RE: 4824 Driftwood Ave NW
Grading and Drainage Plan
Engineer's Stamp Date: 02/05/26
Hydrology File: A12D037
Case # HYDR-2025-00056

Based upon the information provided in your submittal received 02/19/2025, the Grading and Drainage Plan **is not approved** for Grading Permit and Building Permit. The following comments need to be addressed for approval of the above referenced project.

**4824 Driftwood Ave. NW
GRADING PLAN**

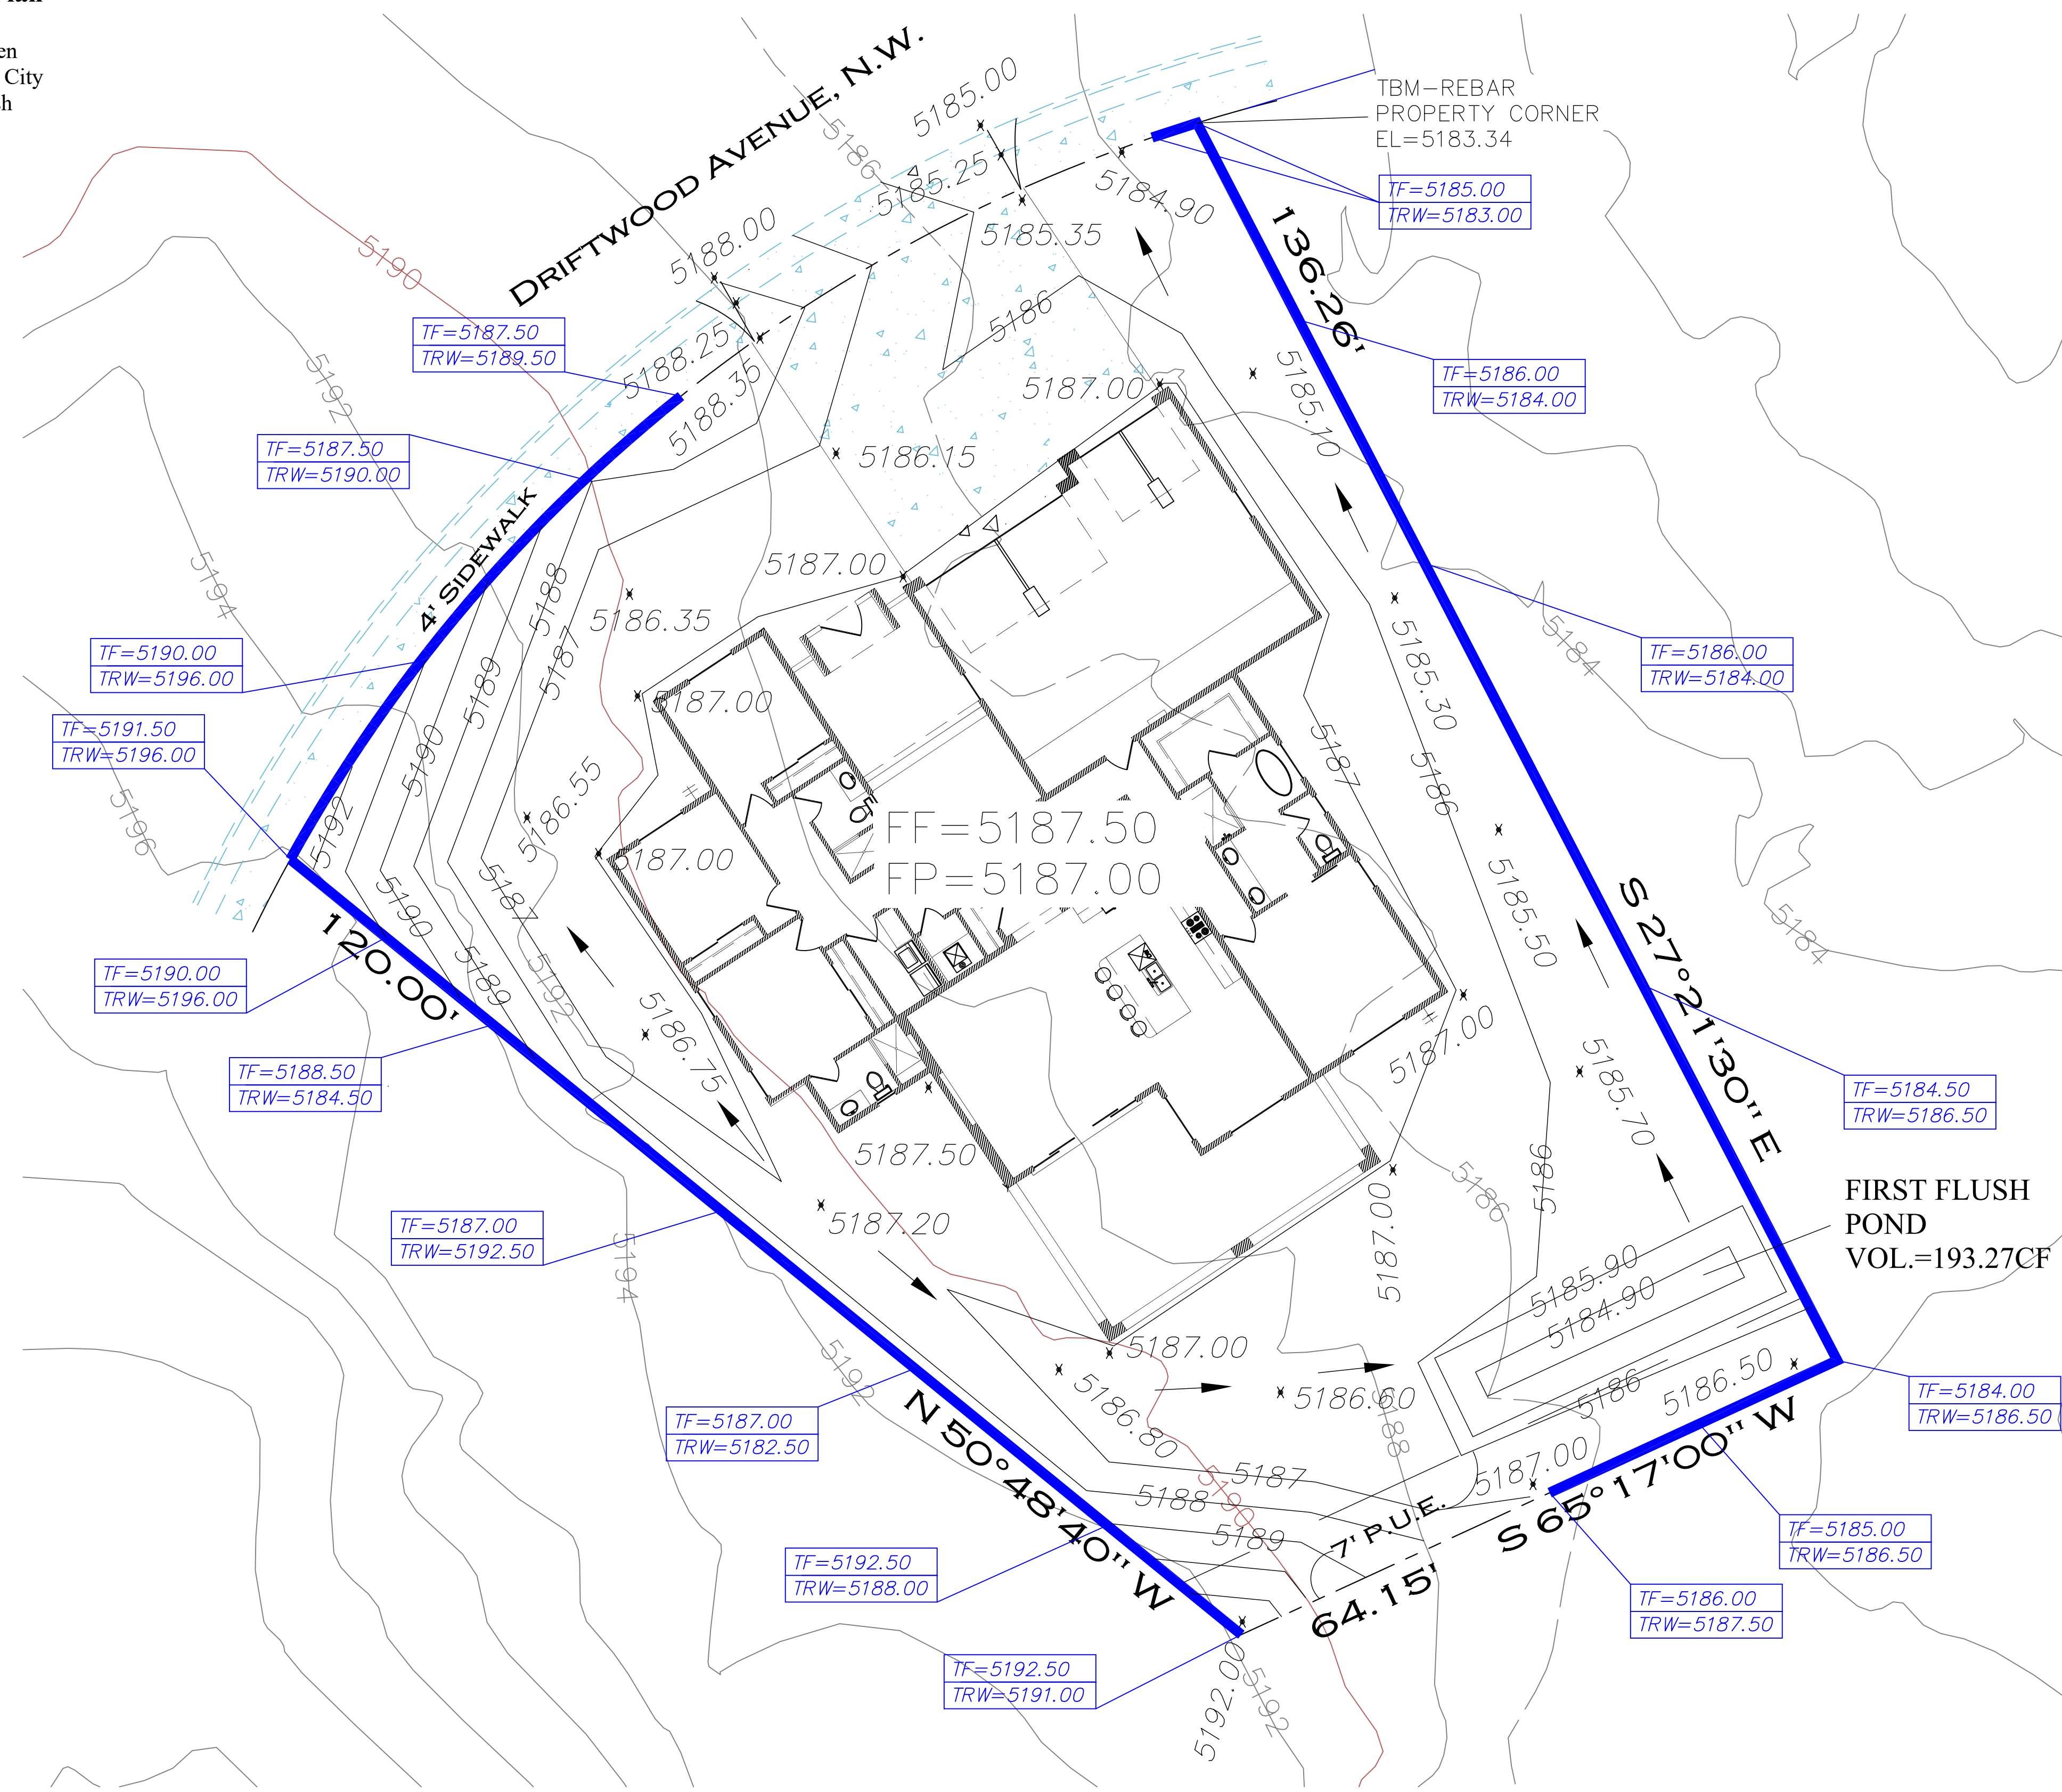
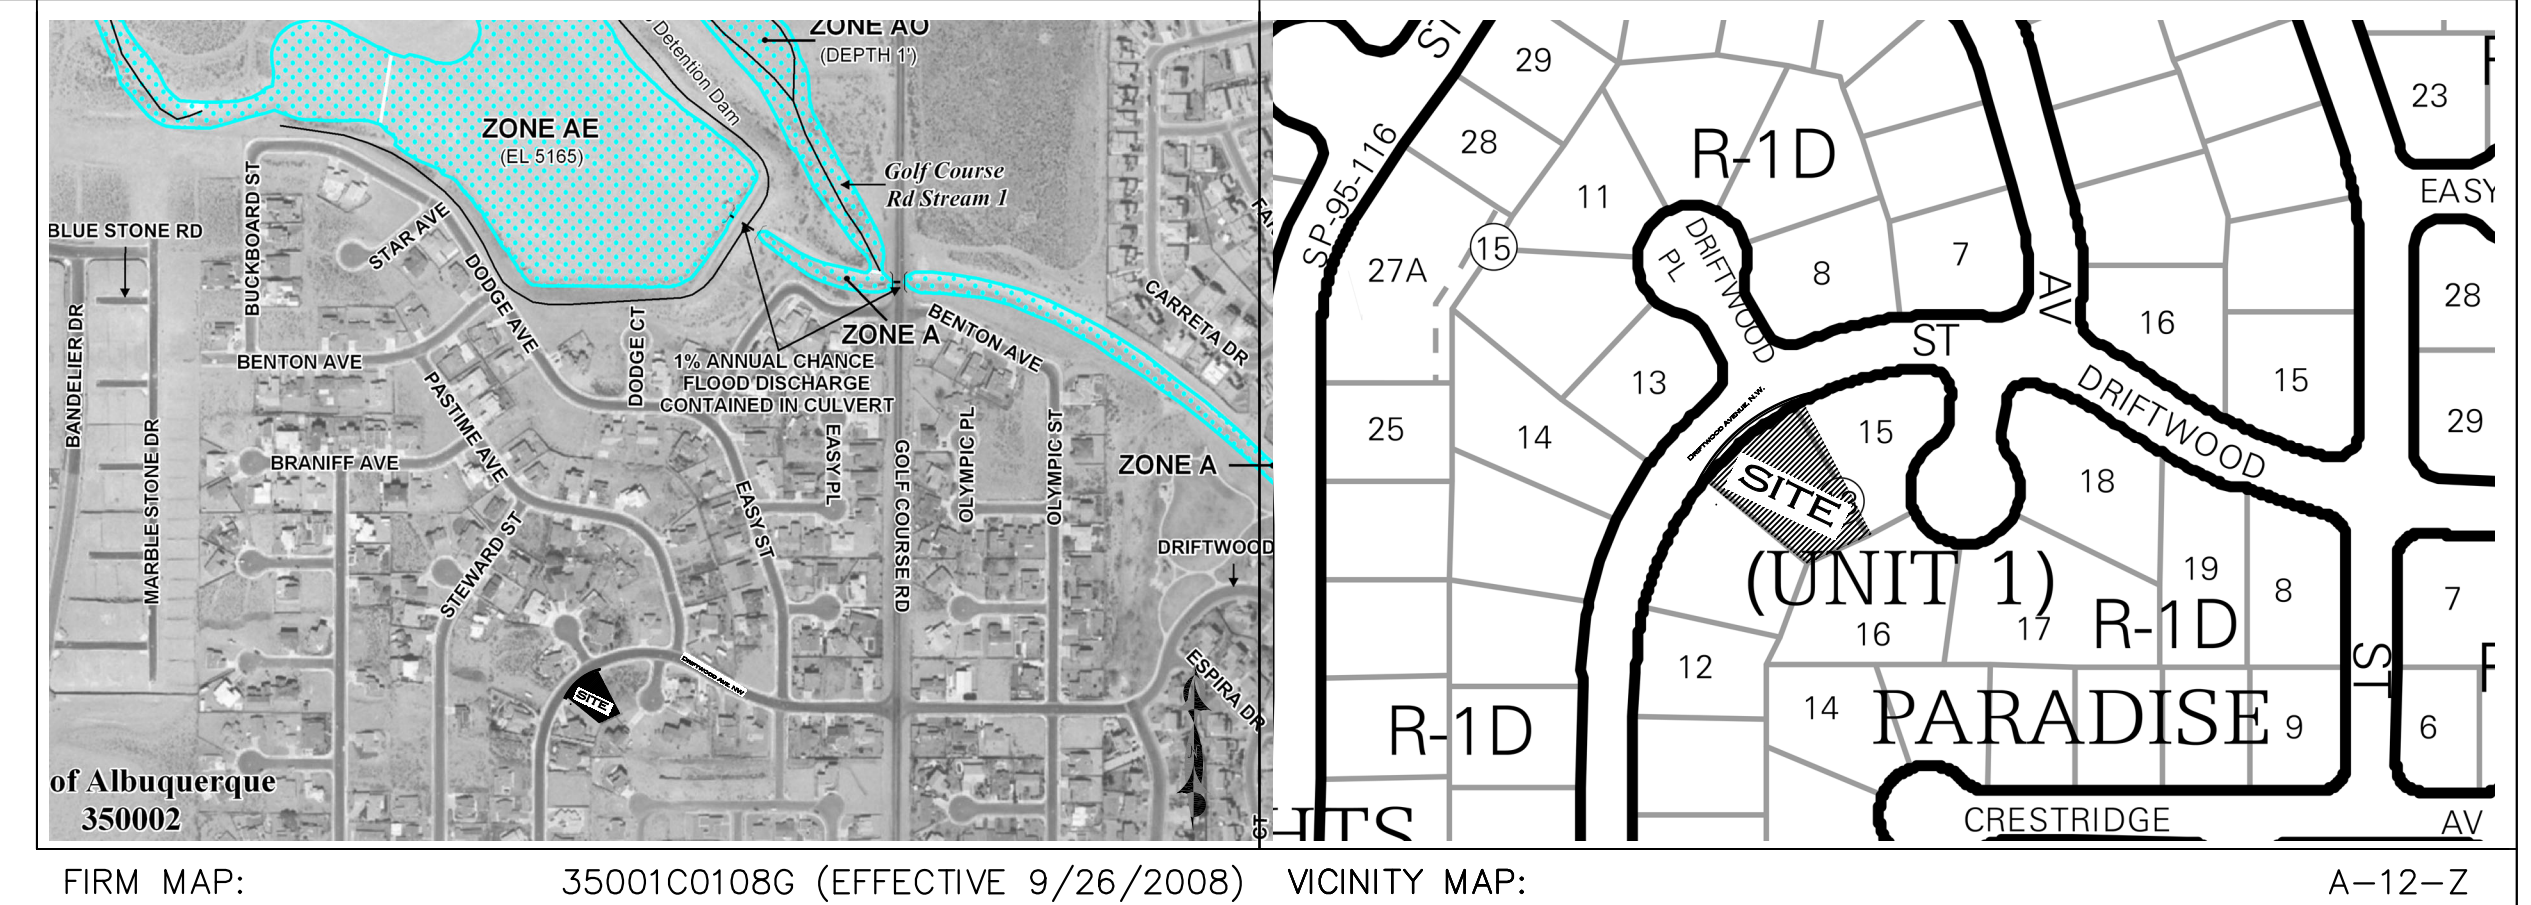
1. Please provide the FIRM Map floodplain note with effective date.

2. Show Finished Pad Elevation.

3. Please clarify why the wall is not extended on southeast side of property.

4. Include project benchmark and datum.
5. Please add a note: "Side slopes need to be stabilized with Native Grass Seed (per City Spec 1012) with Aggregate Mulch or equal (Must satisfy the "Final Stabilization criteria" CGP 2.2.14.b.)".
